**Re: Panda Express at 2040 Gibson Blvd SE (Lot C-2 Lovelace Heights Addition.)
Erosion and Sediment Control Plan
Engineer's Stamp date 11/19/2024 (M15E021F) SWQ-2025-00012**

Based on the information in your submittal received on 2/21/25, the above-referenced ESC Plan can't be approved until the following comments are addressed.

C06.0

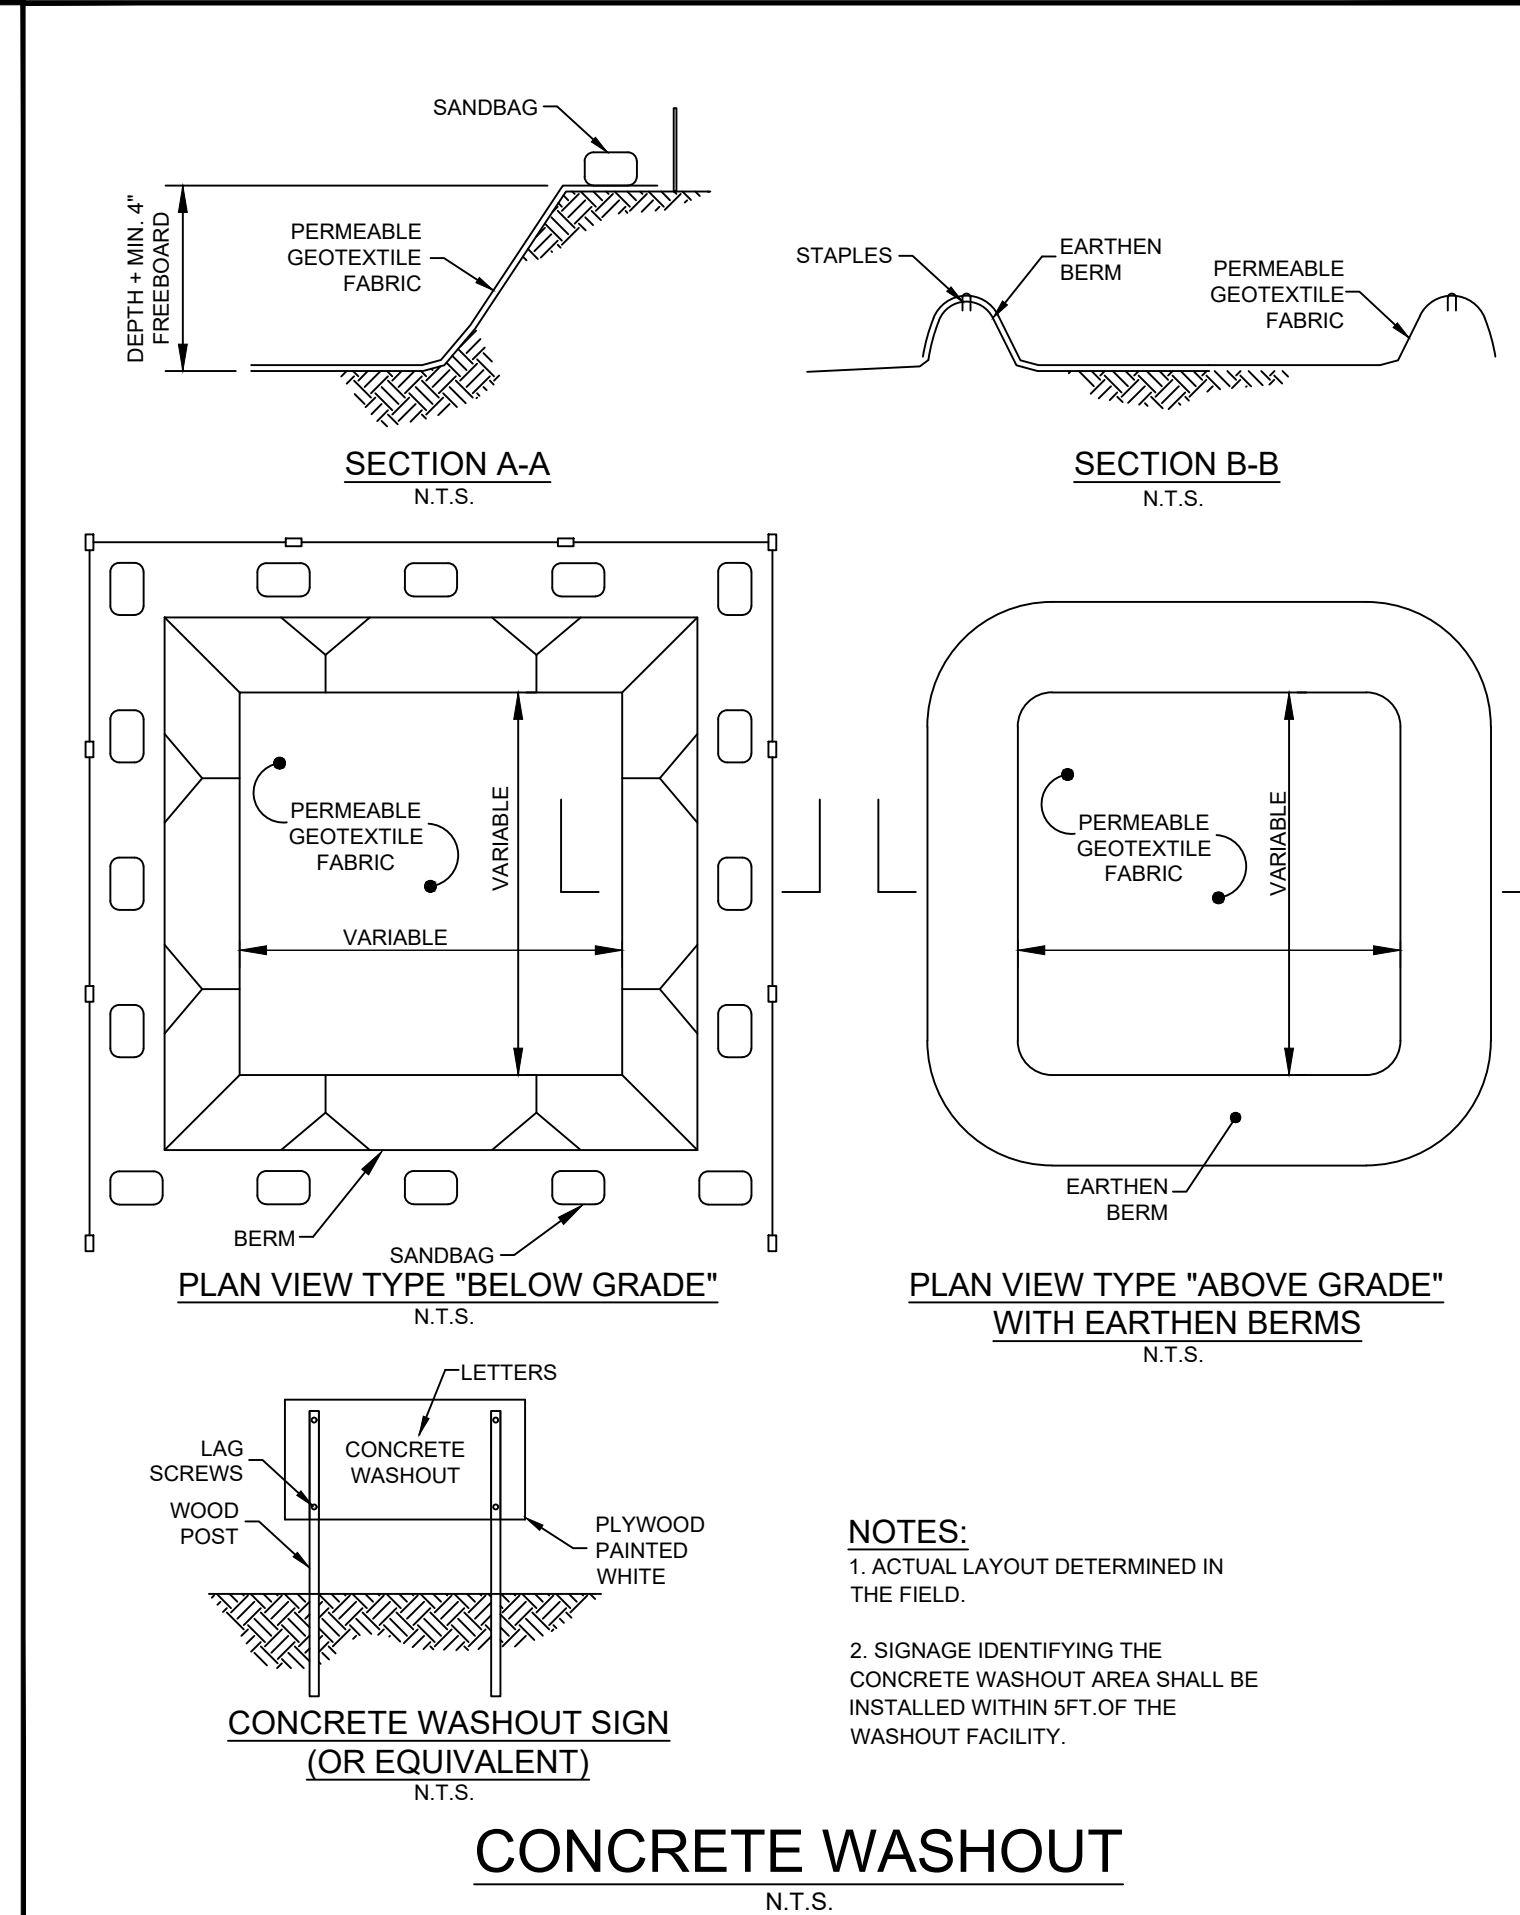
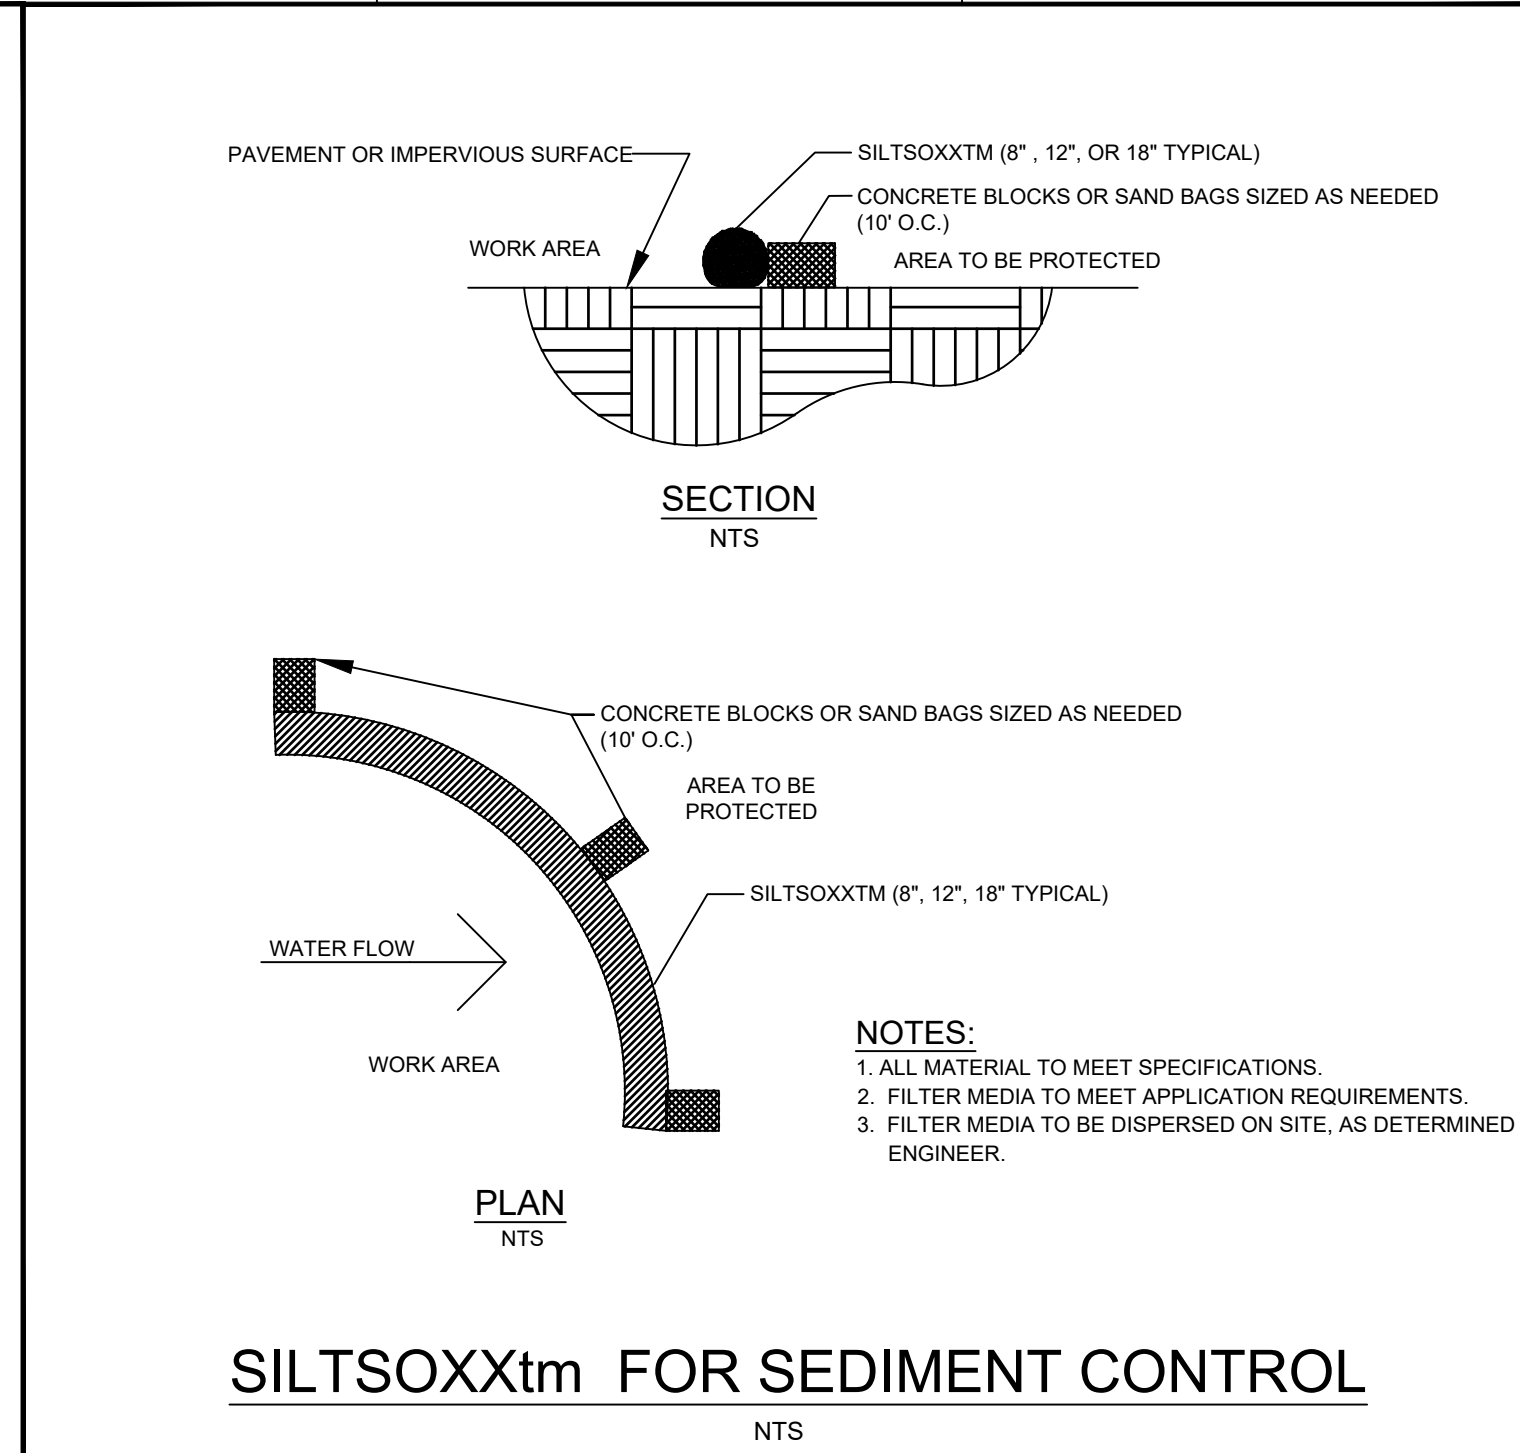
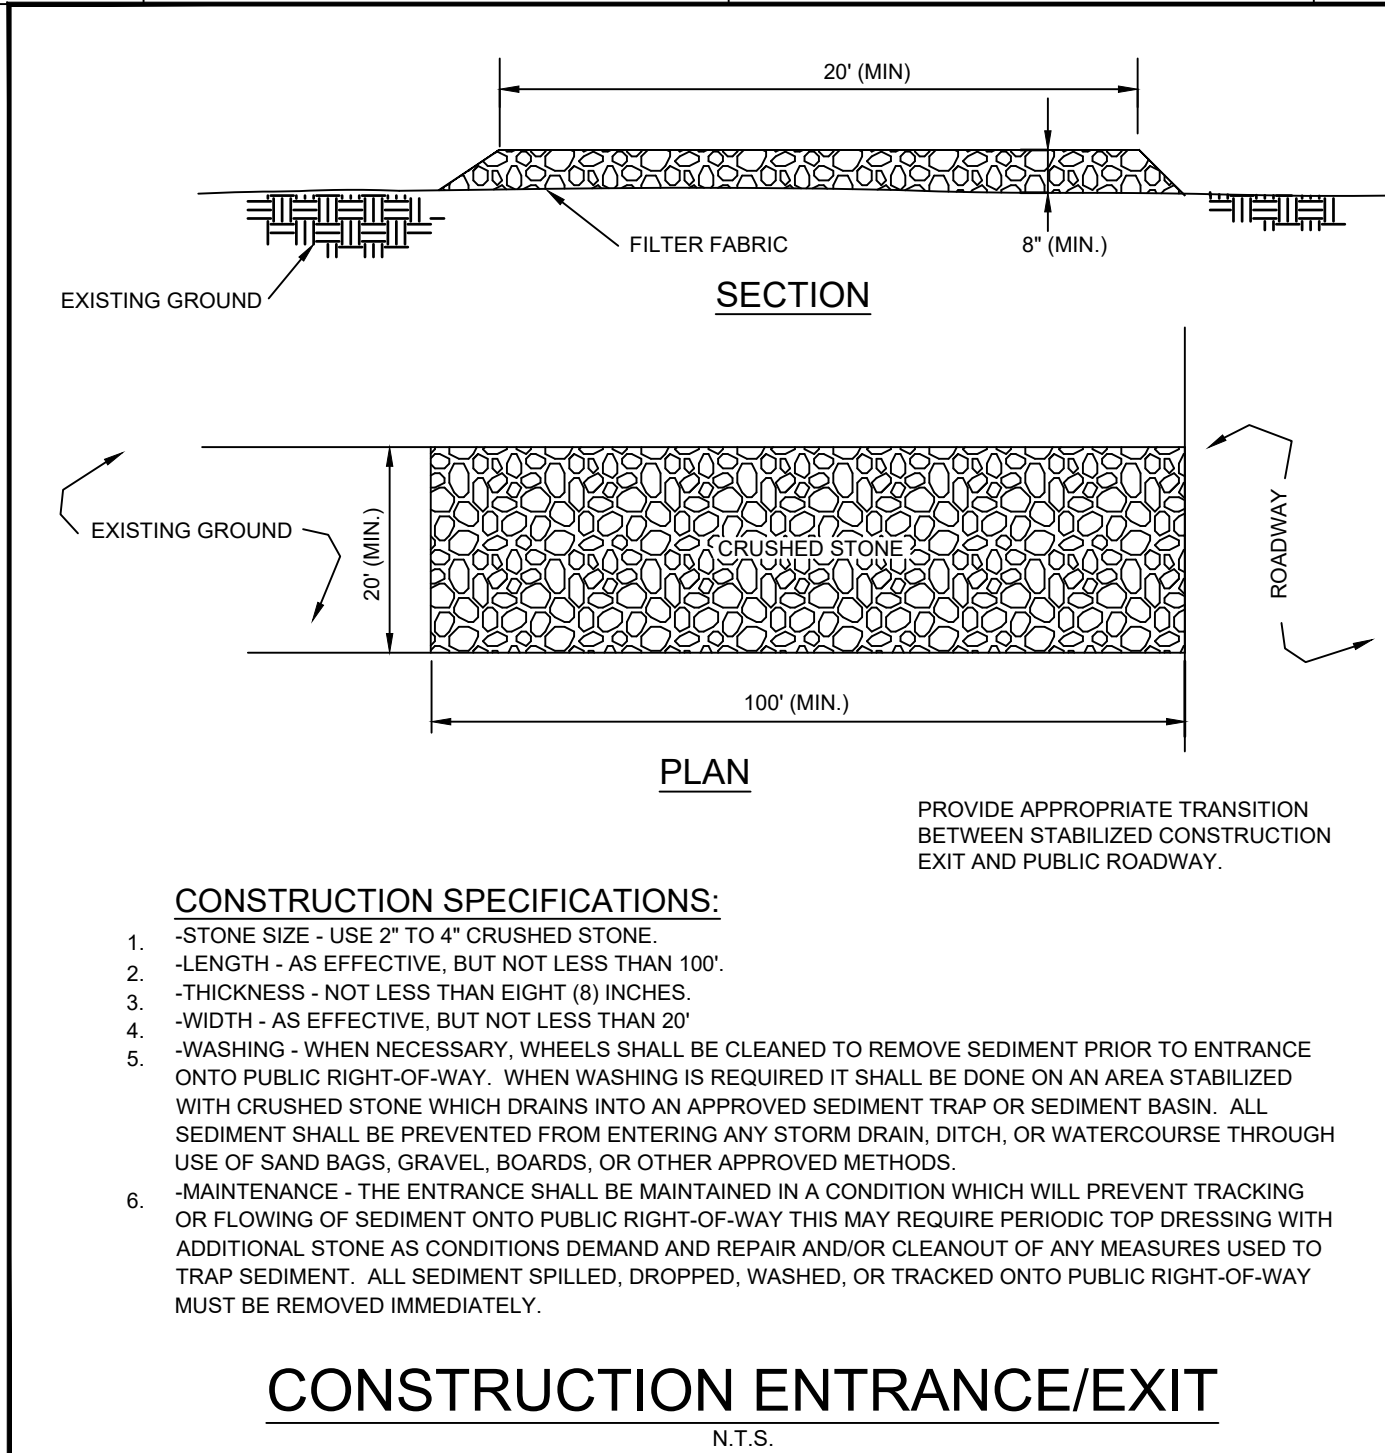
5. The limits of land disturbing activities must include all stockpiles and construction support activities already taking place on the adjacent property, Lot C-1. Also, indicate the areas of control of the two property owners/operators unless all construction support activities are removed from Lot C-1 and the disturbed portions are stabilized with rock per CGP 2.2.14.c.ii before the next City Inspection.

6. The BMPs shown are inadequate. Mulch sock, as shown, isn't an acceptable substitute for Silt Fence. Silt Fence must be shown at the limits of disturbance, including the area of construction support activities and offsite stockpile as a dust control per your Fugitive Dust Permit and CGP 2.2.6. However, Silt Fence alone isn't sufficient to manage the stormwater quality requirements where the silt fence is downhill from disturbed areas, and the Silt Fence isn't located on-contour or the Silt Fence is located at concentrated "Discharge Points." You must identify the Discharge Points on the ESC Plan and add Sediment Traps, one each at the southwest and northwest corners of the site. At all locations downhill from disturbed portions of the site where the Silt Fence isn't on contour, you must add Diversion Berms in addition to the Silt Fence.

8. Describe the nature and extent of construction activities (CGP 7.2.2.) on the ESC Plan. Include the size of the property and the size of the area of land-disturbing activities onsite and offsite. Describe construction support activities and show the staging area on the ESC Plan. Describe the construction sequence, with the placement and removal of the required stormwater controls being the first and last items of construction. Resolve the discrepancy between the controls described in Section 2 of the SWPPP and what is specified in the ESC Plan and add the description and details to the ESC Plan.
